CITY OF ALBUQUERQUE

Re: Self Storage Building Addition
5220 And 5310 San Mateo Blvd NE
Traffic Circulation Layout
Architect's Stamp dated 10-26-16 (F18-D0059)

Subject: F18D059 Self Storage building addition 5310 San Mateo TCL Comments

Re: Self Storage Building Addition
5310 San Mateo Blvd. NE
Traffic Circulation Layout
Architect's Stamp 10-13-16 (F18-D059)

**C2**  
 10/26/2016

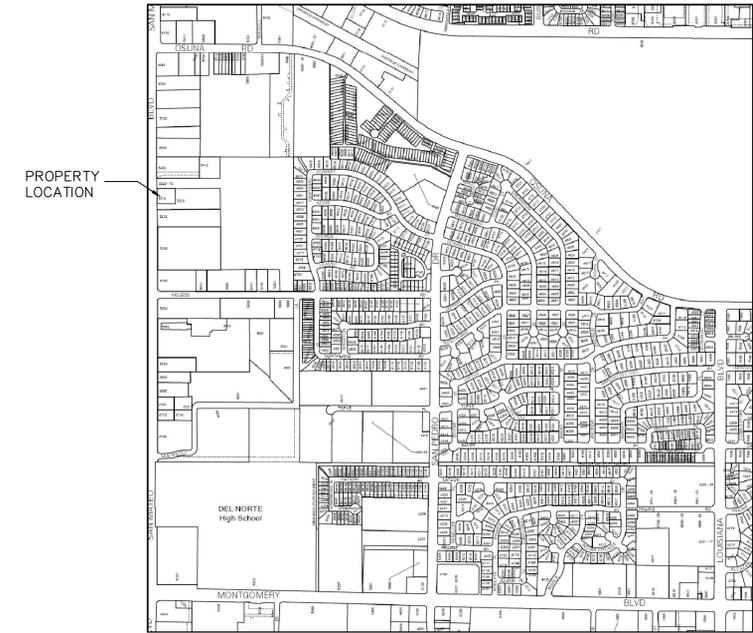
- Addressing the ADA in the notes is ok. I would like to see them in the Key Notes too.
- If you can show the words “No Parking” on the plan view in the proper location it will help the contractor.
- One of the Driveways on the San Mateo should be closed as well. You can make the remaining drive wider if you need.

C2

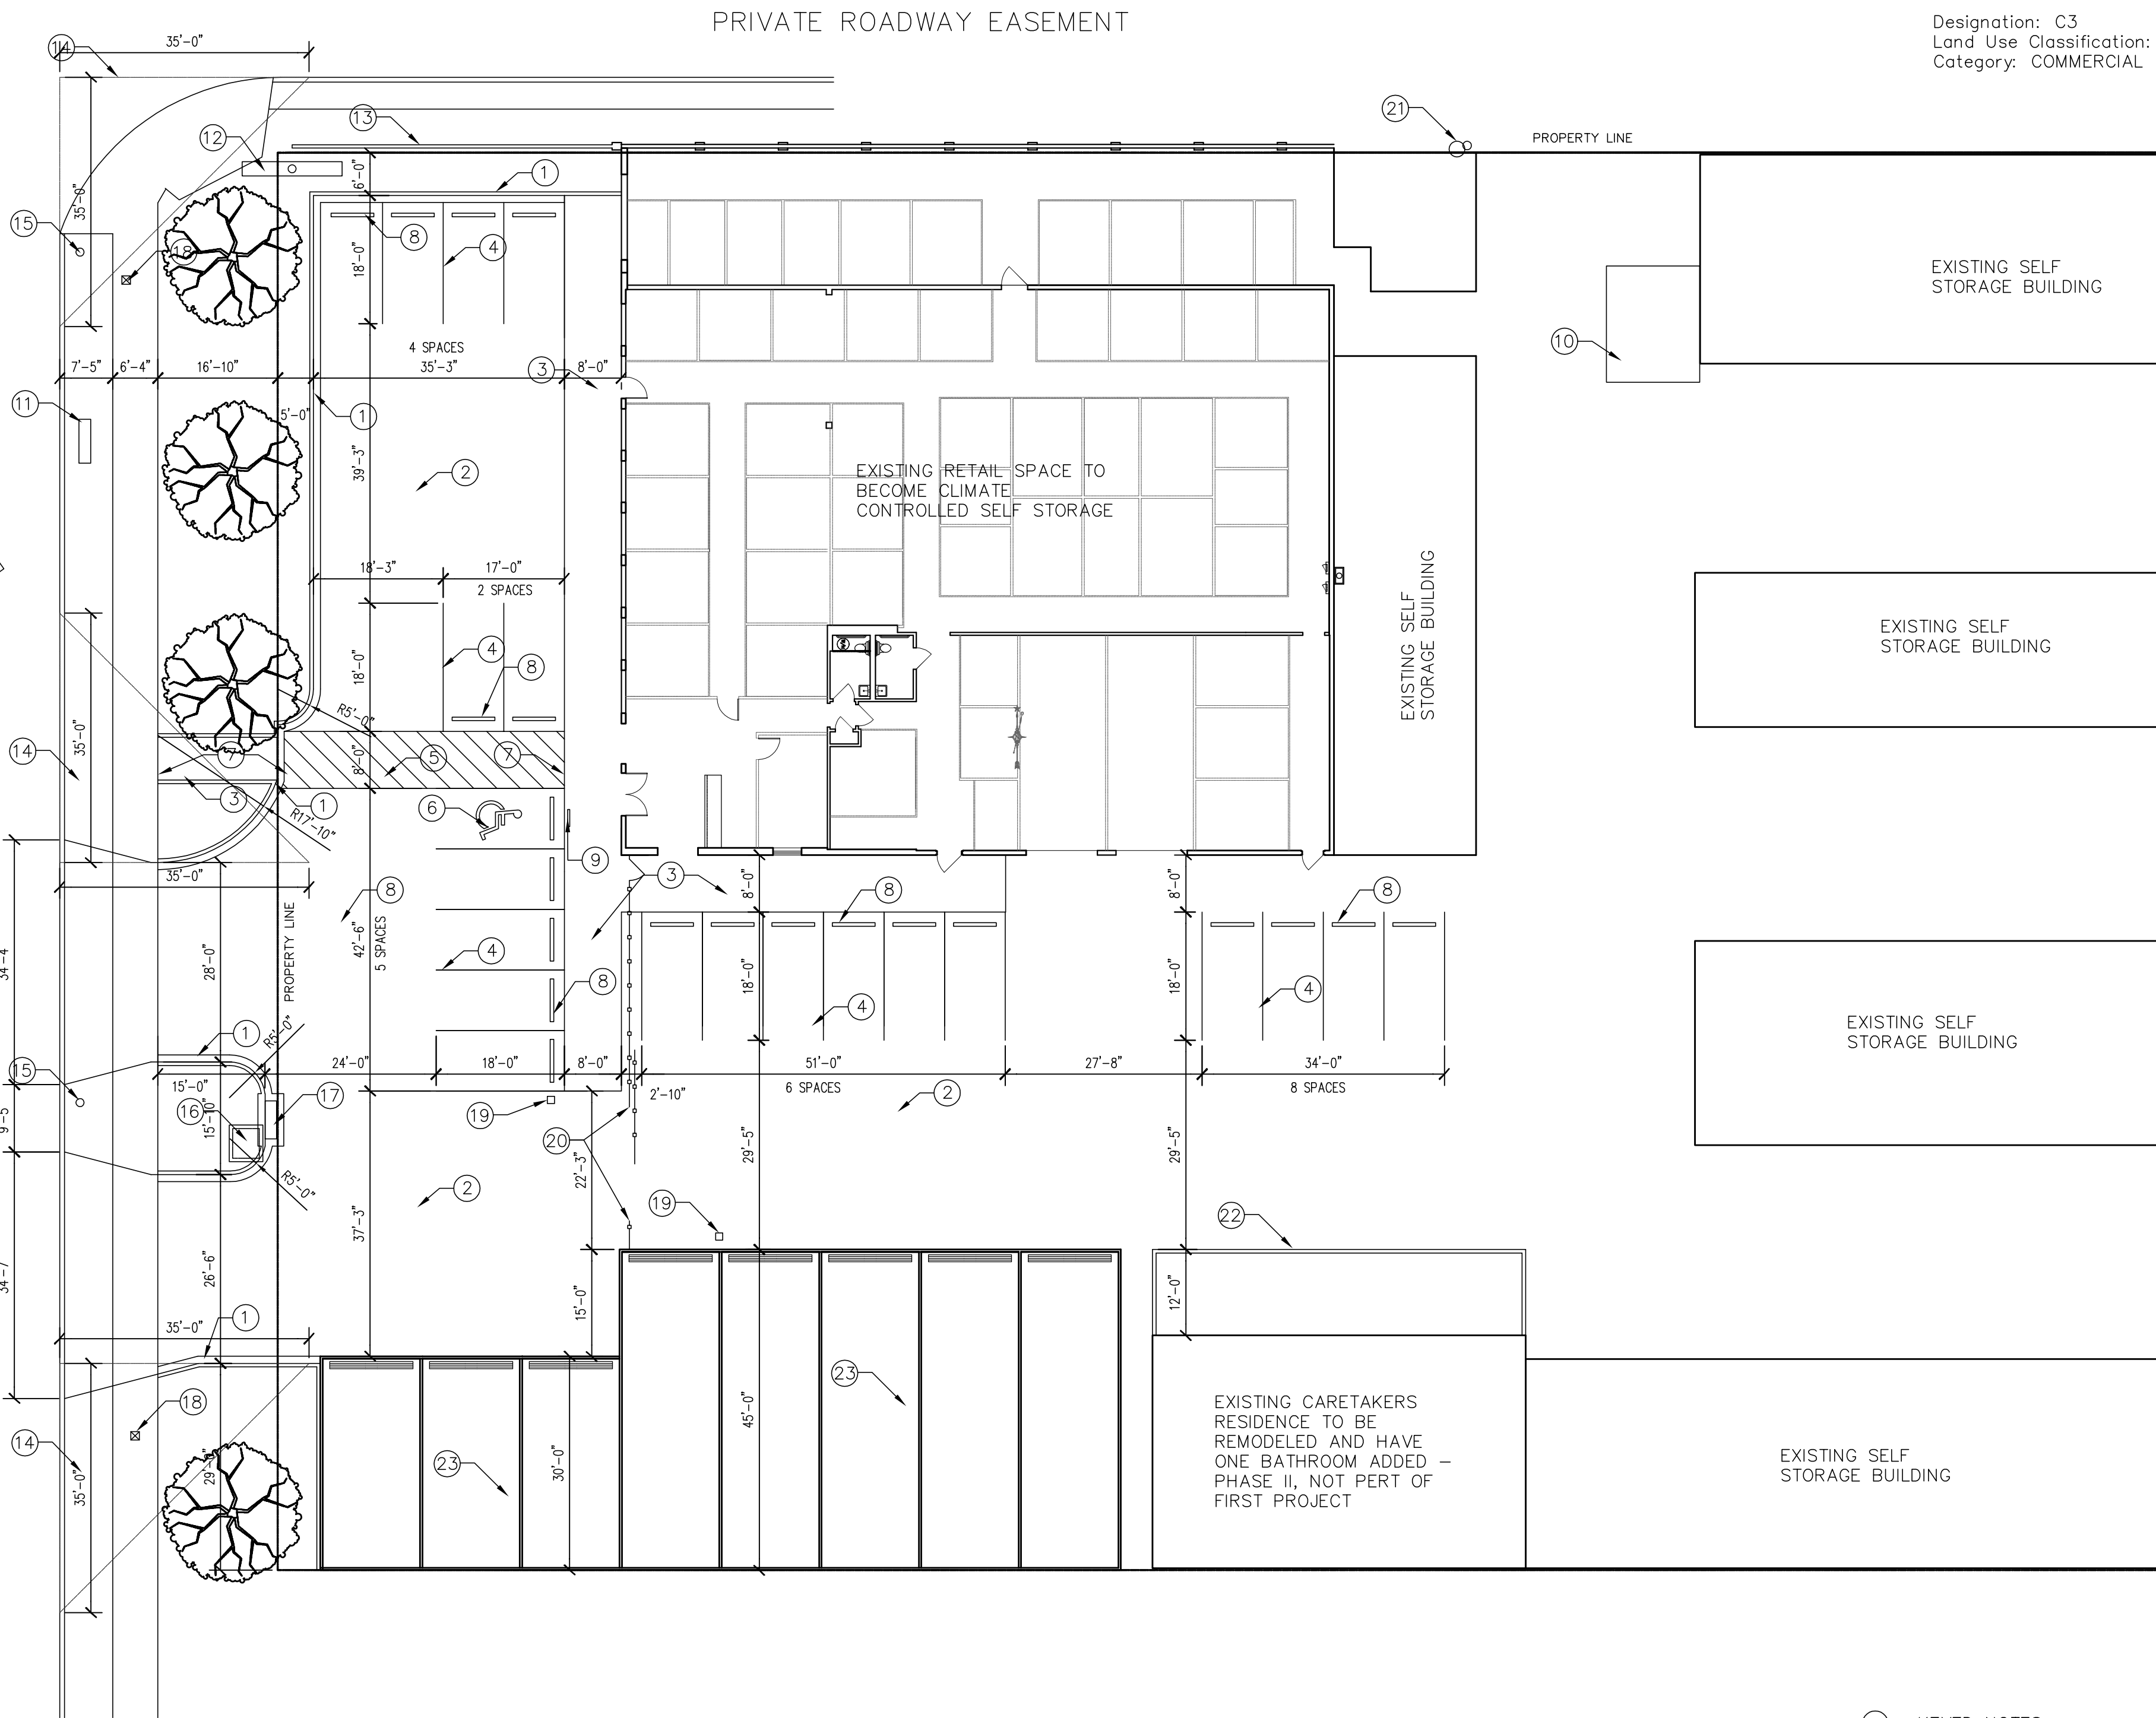
1. Clarify the number of parking spaces required by the zoning code.
2. The ADA accessible parking sign must have the required language per 66-7-352.4C NMSA 1978 **"Violators Are Subject to a Fine and/or Towing."** Please call out detail and location of HC signs.

3. The ADA access aisles shall have the words **"NO PARKING"** in capital letters, each of which shall be at least one foot high and at least two inches wide, placed at the rear of the parking space so as to be close to where an adjacent vehicle's rear tire would be placed. (66-1-4.1.B NMSA 1978)

4. Install an ADA curb ramp with detectable warning surface (truncated domes) at the corner. Add note: "Detectable warning surface shall be cast in place replaceable"

5. Change parking on North West side of the site to head-in parking.
6. Close one driveway curb cut.
7. Remove driveway on corner, unused curb cuts must be replaced with sidewalk and curb & gutter. A build note must be provided referring to the appropriate City Standard drawing.

8. Add a note stating "All broken or cracked sidewalk must be replaced with sidewalk and curb & gutter." A build note must be provided referring to the appropriate City Standard drawing.
